## Department of Planning and Environment

Our ref: DOC22/282259

Your ref: SSI 8609189

**Subject:** Upper South Creek Advanced Water Recycling Centre (SSI-8609189) Response to Submissions Report

**Figure 4-10 WorleyParsons (2015) and AWRC study 1% AEP flood extents using ARR 1987 Guidelines**

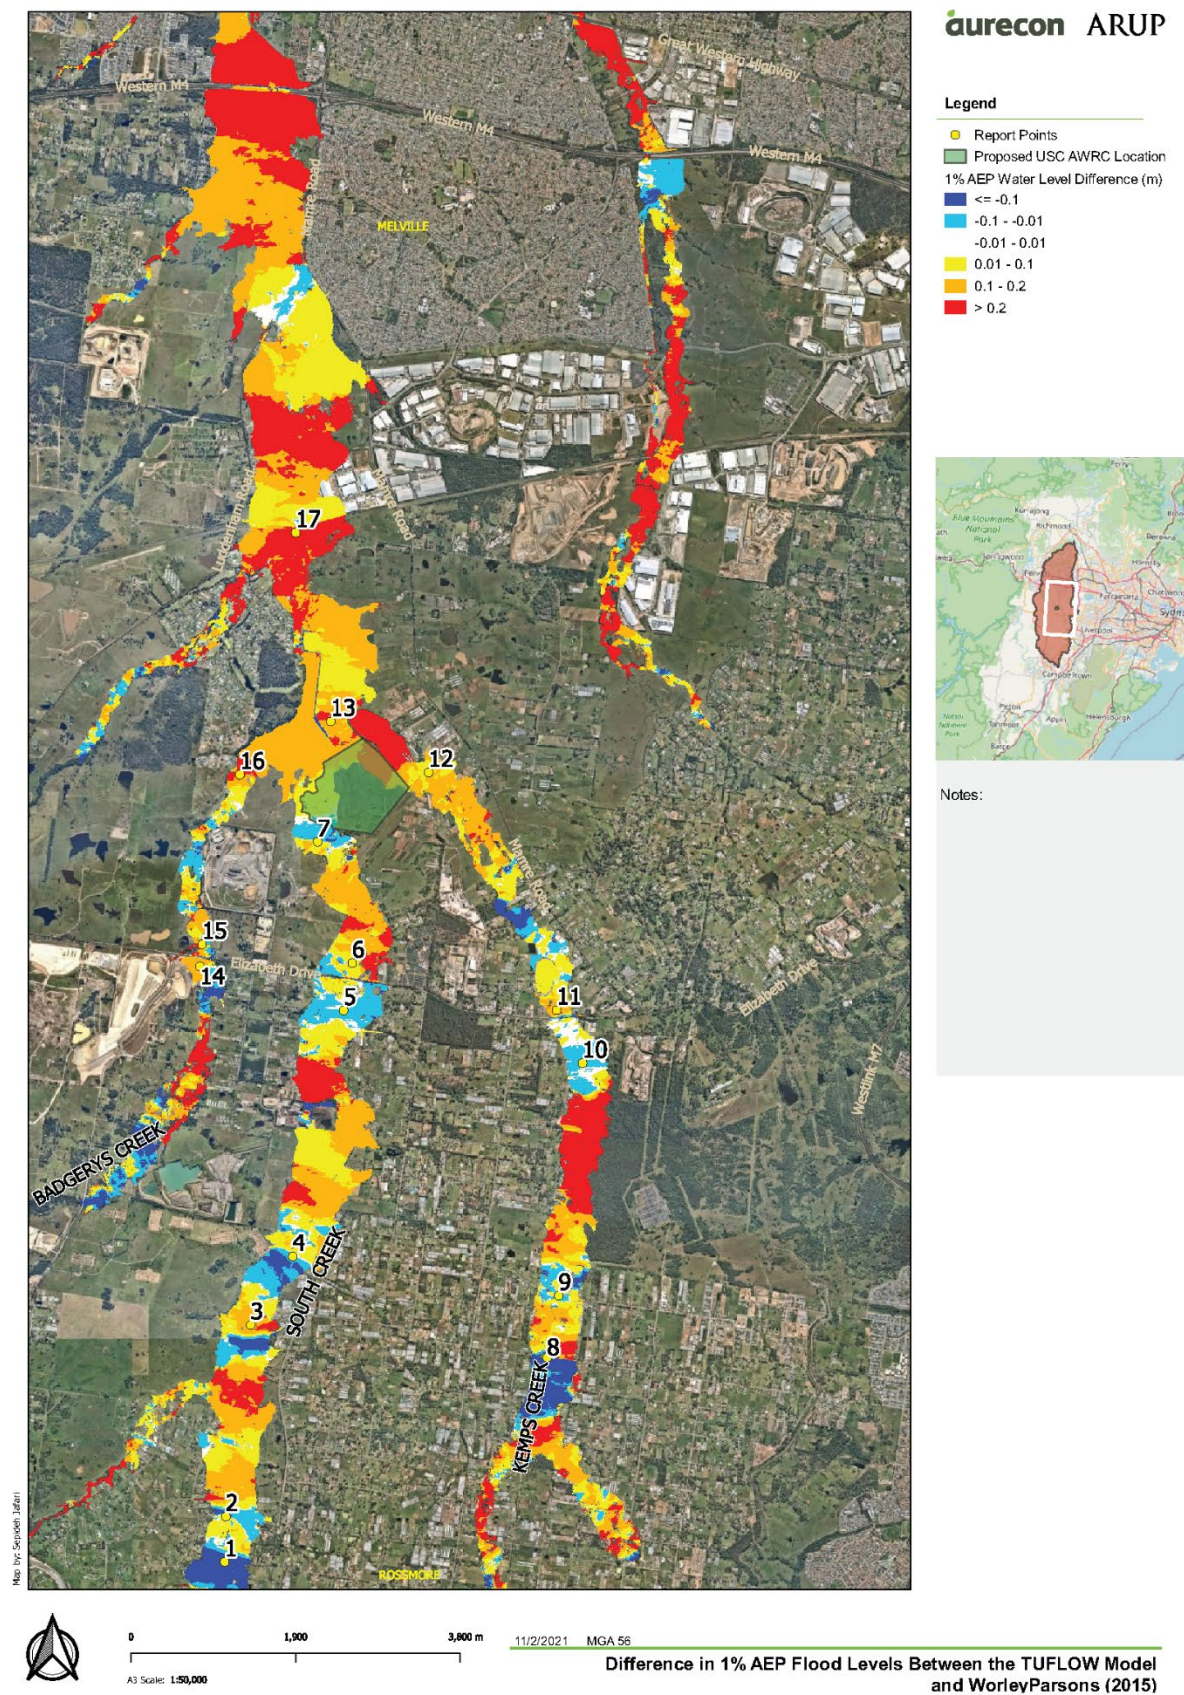
EHG has previously addressed the inconsistency between the Aurecon ARUP flood assessment 2021 results and Penrith's WorleyParsons (2015) results. In addition, the figures below highlight the inconsistency between Aurecon ARUP flood assessment 2021 results and INSW 2020 results.

The figures above show significant inconsistency in flood behaviour results by Aurecon ARUP flood assessment 2021 (bottom figure) comparing to Council’s 2015 results (upper left figure) and INSW flood assessment (upper right figure).
